50 Bayswater Avenue and 1088 Somerset Street West

Urban Design Review Panel Report May 29, 2024

RE: Urban Design Review Panel Report 50 Bayswater Avenue and 1088 Somerset Street West–Zoning By-law Amendment and Site Plan Control

Please find RLA responses in red below:

1 SITE PLAN
SCALE 1:150

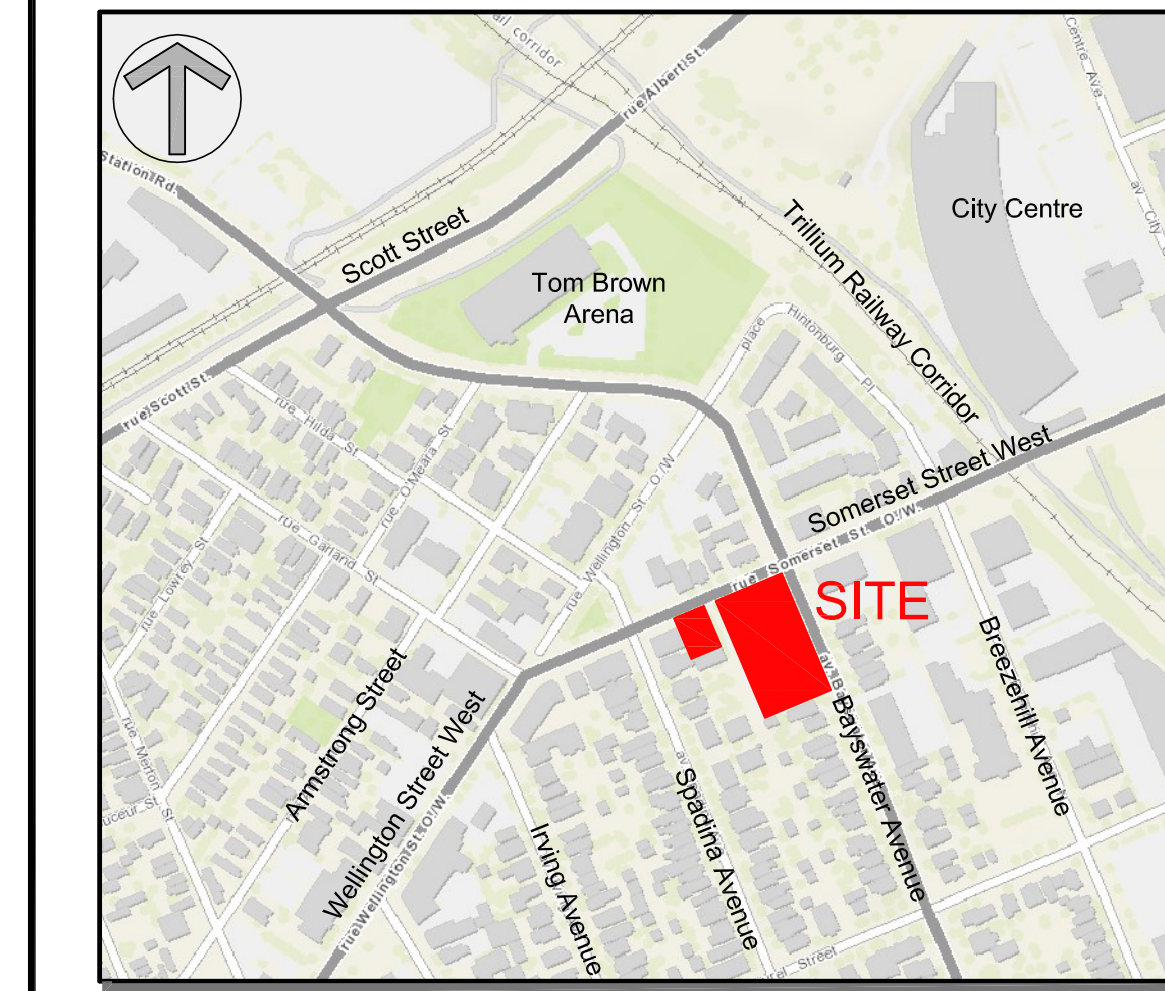
- Consider the opportunity to provide a larger landscaping gesture along Bayswater Avenue in front of the existing apartment building, retaining the existing trees as much as possible.

- Consider greening the surface level parking behind the existing apartment into a beautiful amenity terrace in the future. Potential for a more landscaped private amenity is a fantastic opportunity.

- Noted, please see the updated site plan.
- The Panel has concerns with the site being overparked, and recommends reconsidering the economics of building extra parking spaces.

- A portion of the surface is being converted to green amenity space above the ramp on Bayswater. The proposed development adds 101 new units, and is only providing 16 new parking spots (16%). The surface parking level is currently in high demand from the existing building, and will be more so with the new units. If parking demand decreases in the future with increased transit accessibility, plans can be made to convert the surface parking into green amenity space.

2 SOMERSET STREET W ELEVATION
A-110 1:200

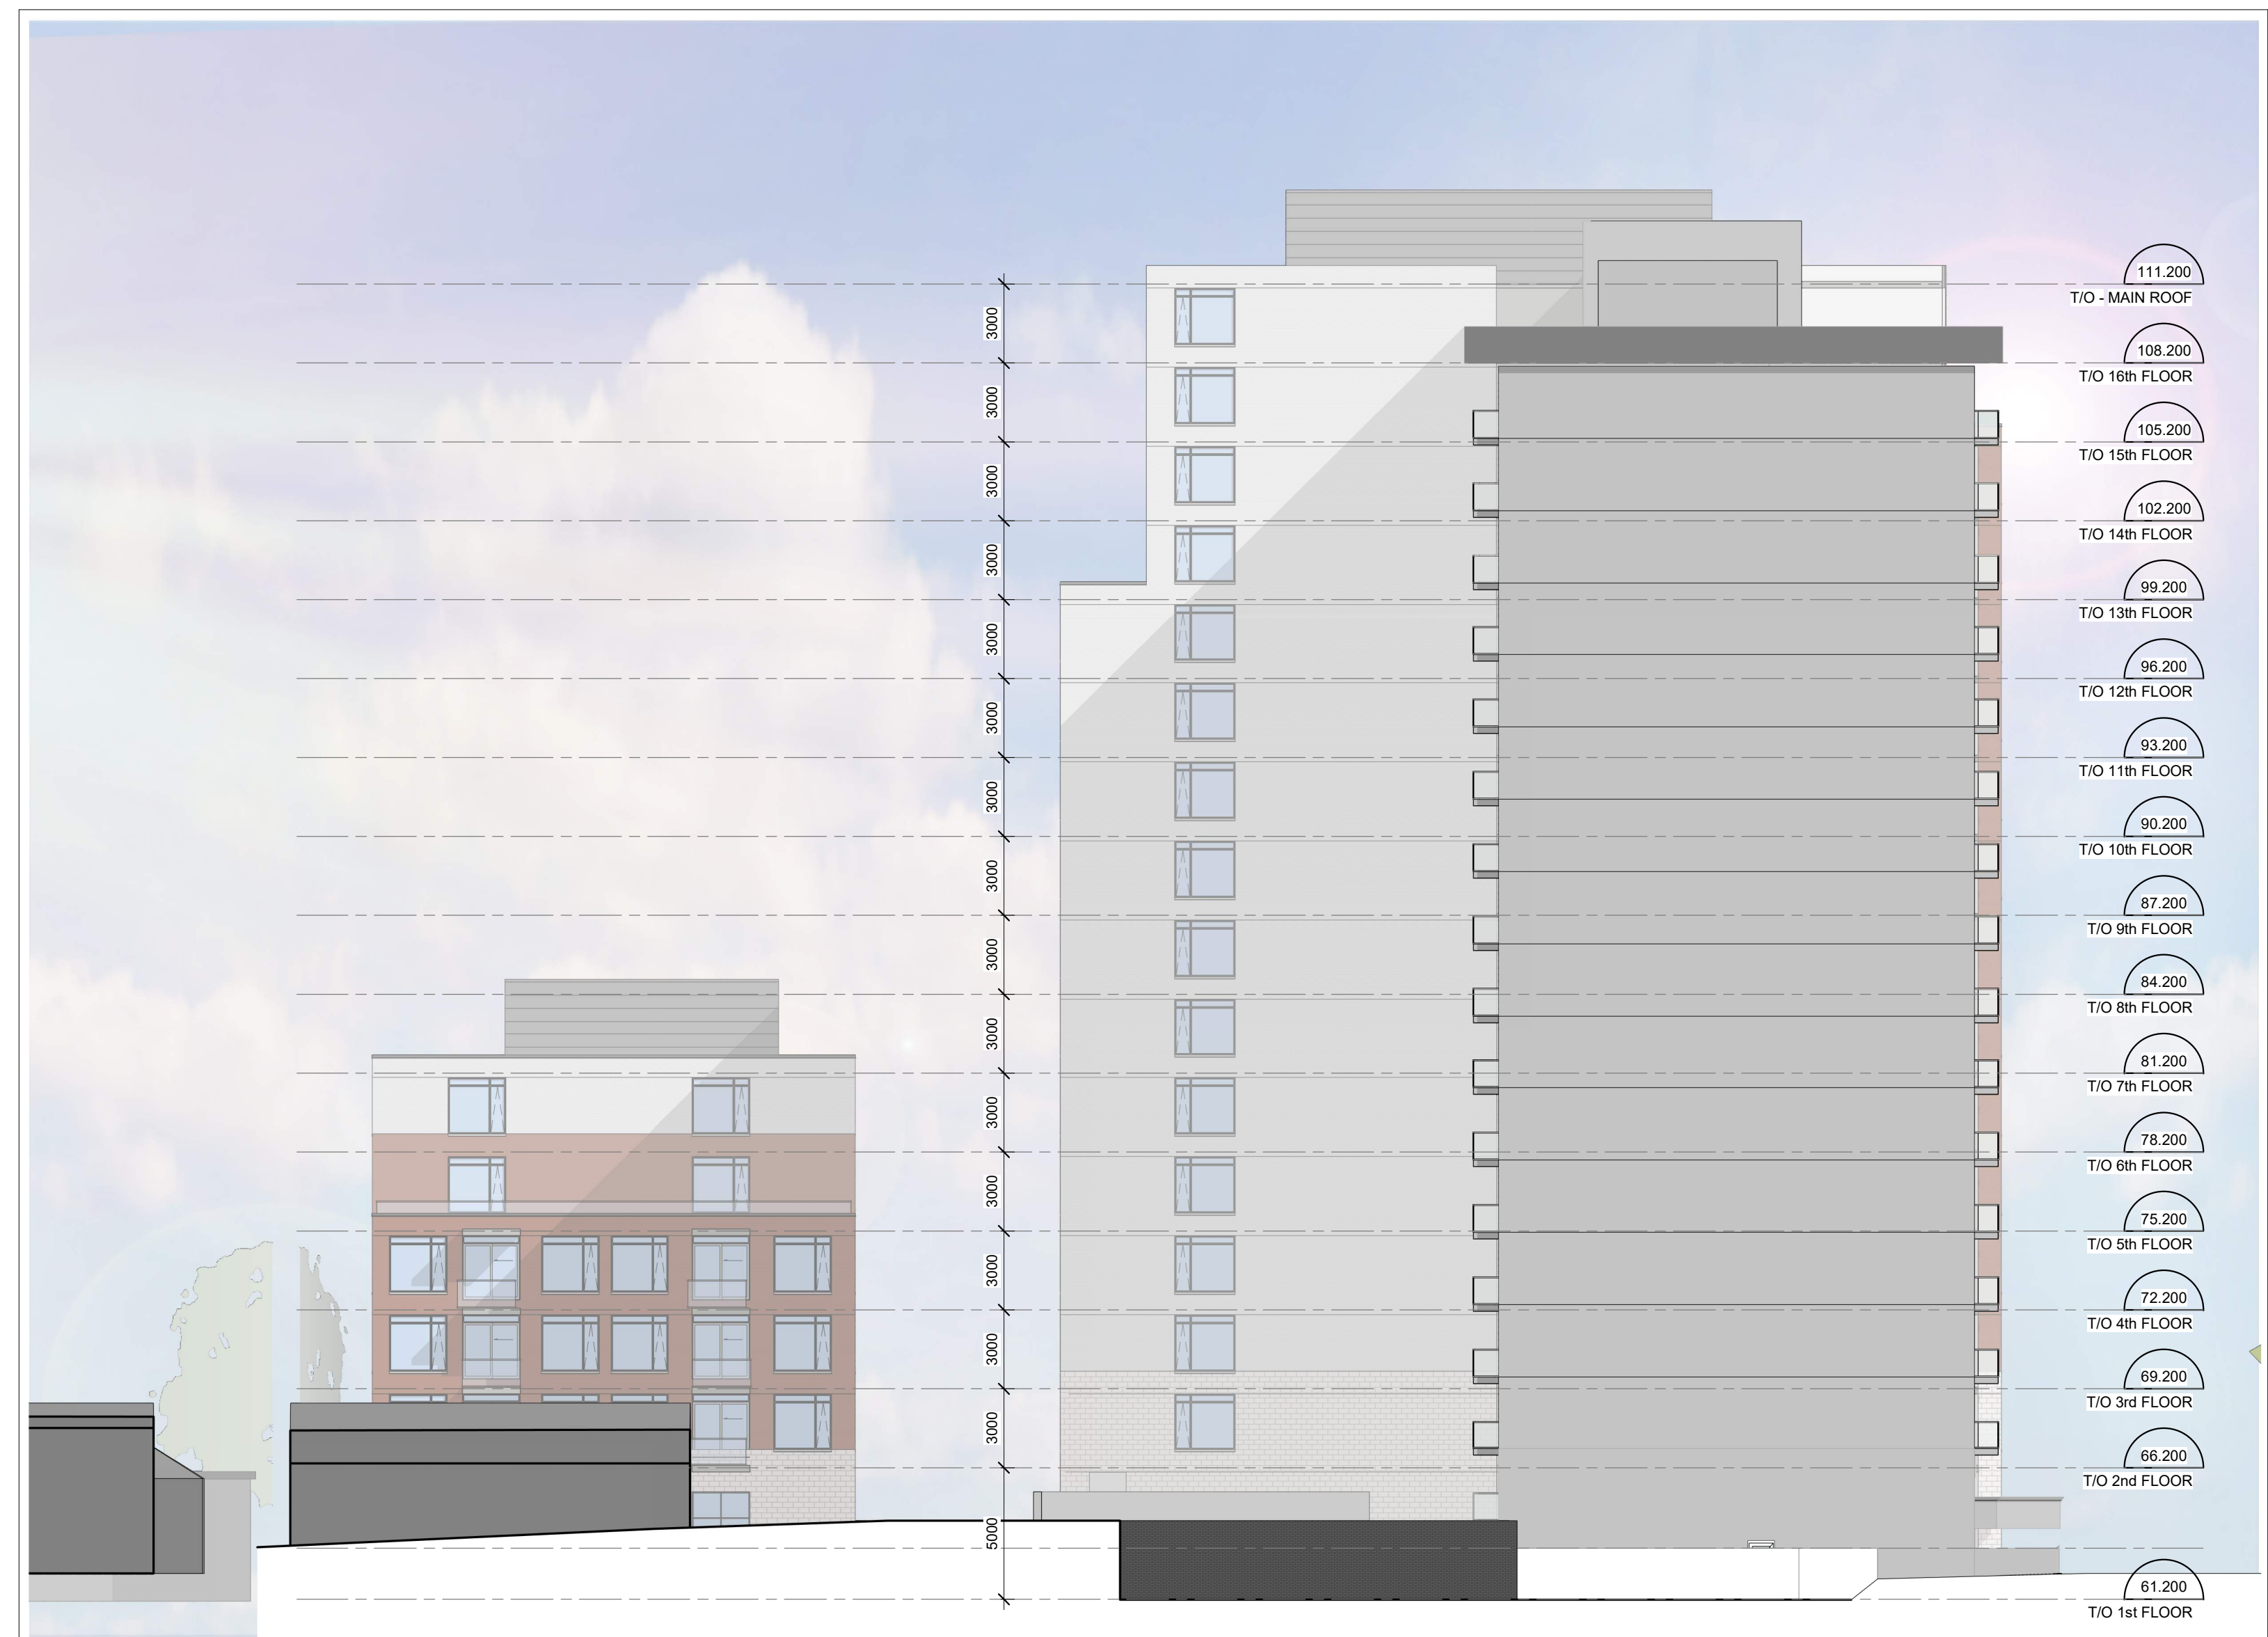
- The Panel recommends revising the height and datum lines of the tower building to better reflect the Traditional Mainstreet character of Somerset Street West.

- Consider a 1-2 storey datum line for a podium feel, and a step-back at the 4-6 storey height so as to express the building more as a mainstreet mid-rise built form prior to the tower portion above.

- Consider more of a Mainstreet built-form proportion with a 2-storey datum, 6-storey datum, and 9-storey datum.
 - Please see the revised elevations. We have revised the podium on the tower building to 2 storeys. We considered a 6-storey datum line, however we felt the proposed revised elevation has a built in transition to the 6 storey building to the west side of the city laneway. We disagreed with introducing a set back at the 9th floor as this negatively impacts housing affordability and the balance of the built form. As a result, we have introduced a set back above the 12th floor.

- The Panel strongly recommends setting back the upper floors at a lower level rather than the proposed 13th storey step-back.
 - o Noted, see note above.

- The Panel recommends considering how the materials wrap around the building to enhance the volume such that the finish on Somerset Street West does not appear as a one-sided veneer.

- The Panel recommends refining the eastern corner expression at Bayswater Avenue to enhance the 3-dimensional articulation of the corner rather than a veneer expression.

- The Panel recommends increasing the podium expression to 2-storeys on both buildings, with an additional datum plane at the 6-storey level and a step-back at the 9th storey of the tower building instead of the proposed 13th storey step-back.

- We have revised the tower building to a 2-storey podium. We believe that
 a 1-storey podium on the mid-rise building is more appropriate.
 Discussion with Hydro Ottawa continue but the existing hydro lines and
 the existing narrow sidewalk along Somerset does not allow for the
 traditional main street setback after the fourth floor. We have elected to
 set the podium back in line with the building above to support an
 enhanced public realm.

- Noted, please see the updated elevations. You will note that we have tied the ground floor podium and the 12th floor somerset façade to the southern wall adjacent to the existing building.

- Please see the revised elevations. The two-storey commercial expression on the tower, and the one-storey on the midrise is consistent with the existing built form. We considered a six-storey datum line however we felt the proposed revised elevation has a built-in transition to the six-storey building on the west side of the city lane. You will note that we have introduced a set back above the 12th floor and the 14th floor
